The Planning Inspectorate

Our ref. XA/2025/100238/02-L01

SUMMARY: PRE-EXAMINATION INTERESTED PARTY RELEVANT REPRESENTATION.

MORGAN AND MORECAMBE OFFSHORE WIND FARMS TRANSMISSION ASSETS

Figure 1 : Indicative Cross Section of the River Ribble Crossing (refer to the Onshore Works Plans (APP-154))

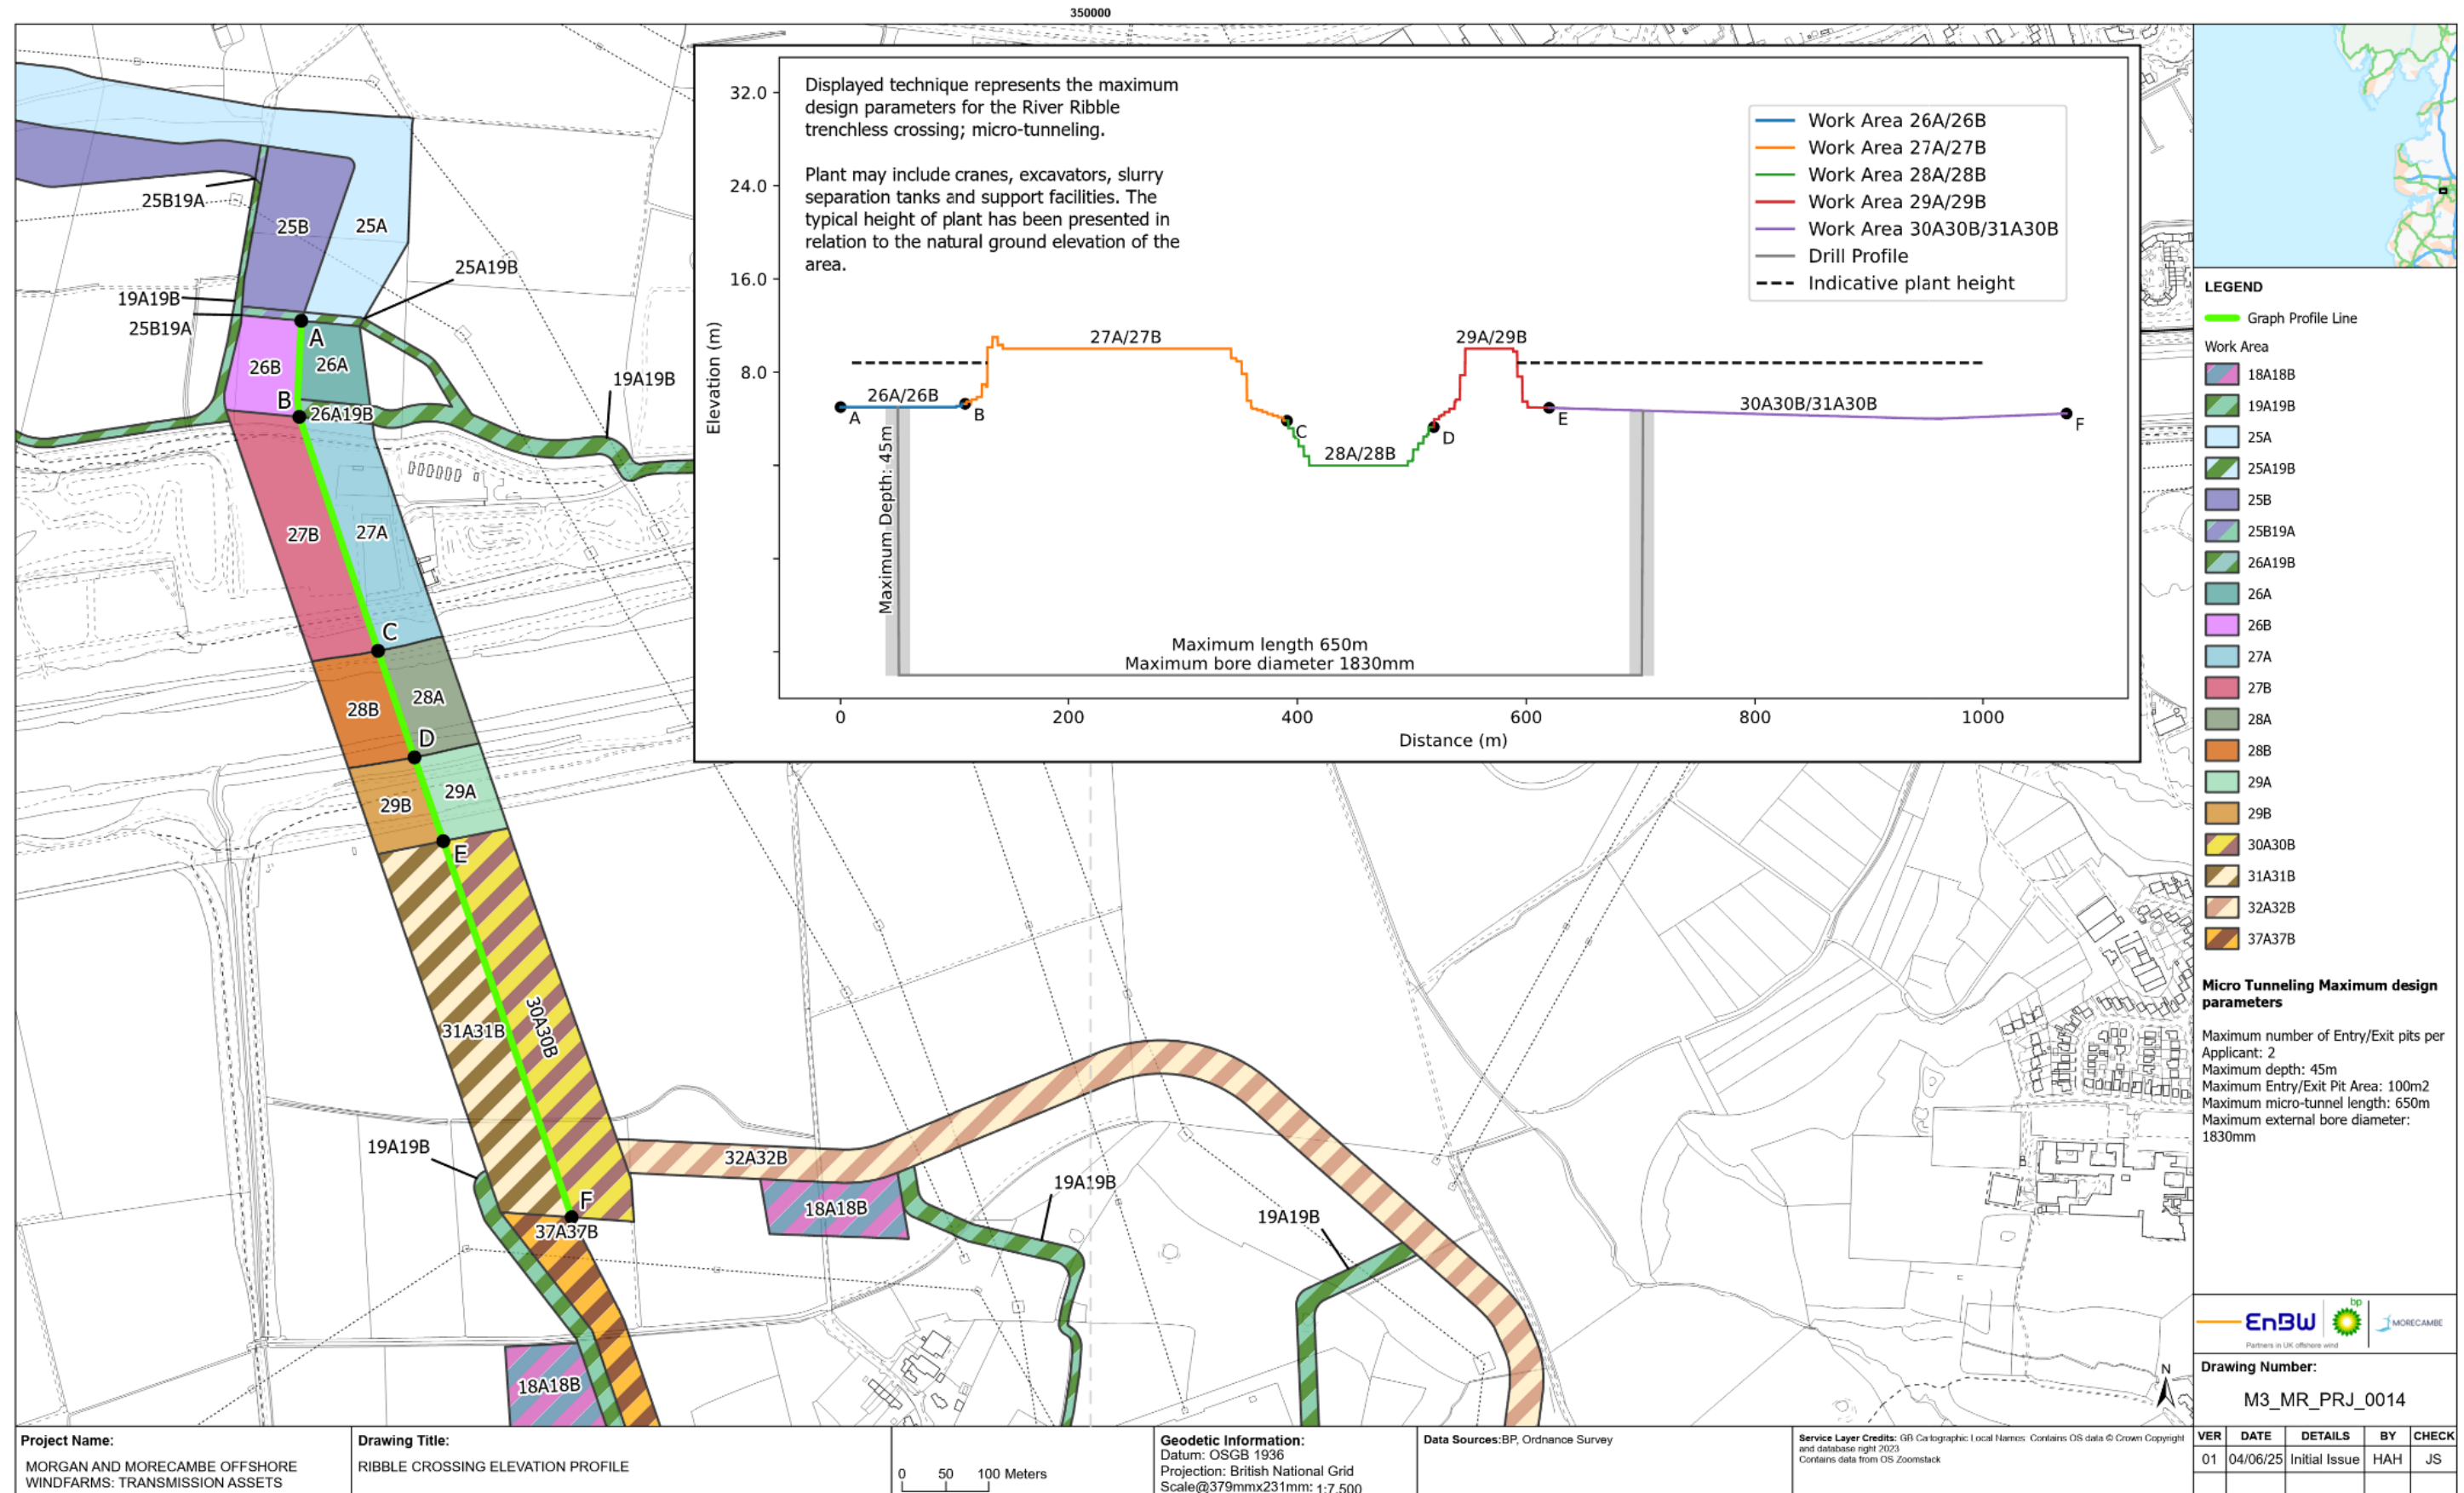
To manage the risks associated with the instillation of the cables a Hydrogeological risk assessment is required for the installation of cables beneath the sand dunes, and for the River Ribble crossing. These must include risk assessment and clarification of the depths of the dewatering that will be required for entry/exit shafts. Please see Appendix 2 for suggested text for requirements.
